TECHNICAL NOTE

Reference: P0421t04v02

Revised Response to Submissions Ivanhoe Estate, Macquarie Park (SSD 8707)

Figure 1: 2031 AM and PM PeakTraffic Volumes with left in on Epping Road

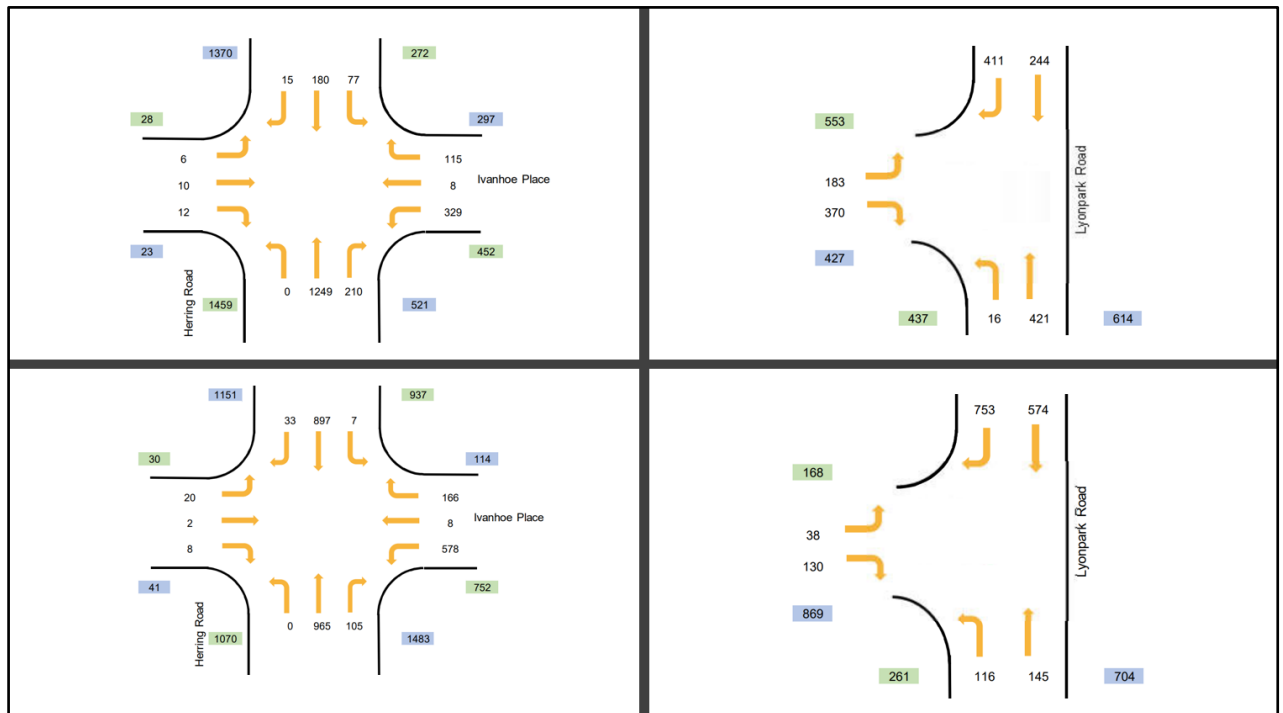
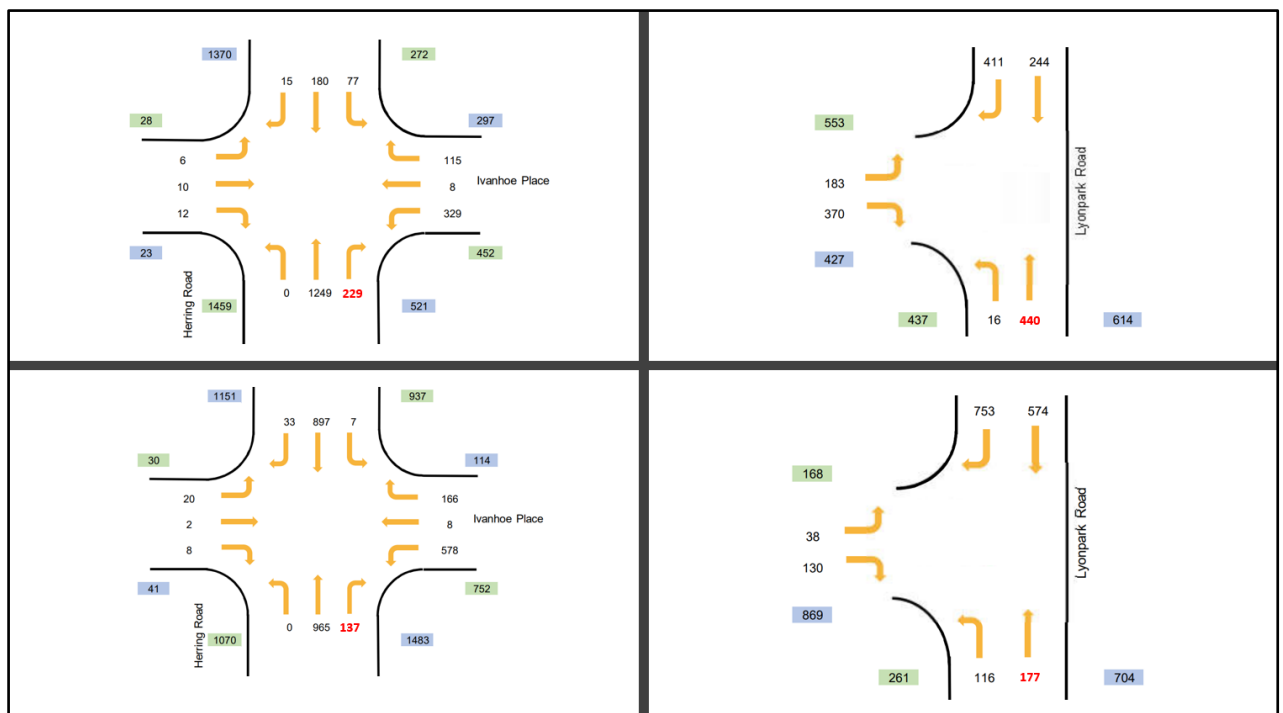
Council seeks that a condition be imposed requiring the applicant/developer to construct a roundabout at the intersection of Road No. 1 / Road No. 2 and Road No. 1 / Road No. 3. This must be incorporated as part of the appropriate stages of construction. Suitably prepared civil plans shall be submitted to and approved by City of Ryde prior to the determination of any detailed application relevant to the particular stage.

Ason Group has request information from Council in regard to the justification for these roundabouts, but no information has been made available by Council as to their purpose. Notwithstanding, SIDRA analysis has been undertaken to examine the future operation of these intersections using the traffic volumes extracted from the Aimsun model. These volumes are shown in **Figure 1** and **Figure 2** below, noting that Road No. 1 is referred to as Main Street in these Aimsun outputs.

These SIDRA results demonstrate that both the Main Street intersections will operate with very good levels of service under the future development scenarios (for both the 2021 and 2031 horizon years). As such, it is the conclusion of Ason Group that there is no reasonable justification for the provision of roundabouts at these intersections instead of the proposed priority control, particularly when [the provision of the roundabouts would results in the significant loss of social housing dwellings.
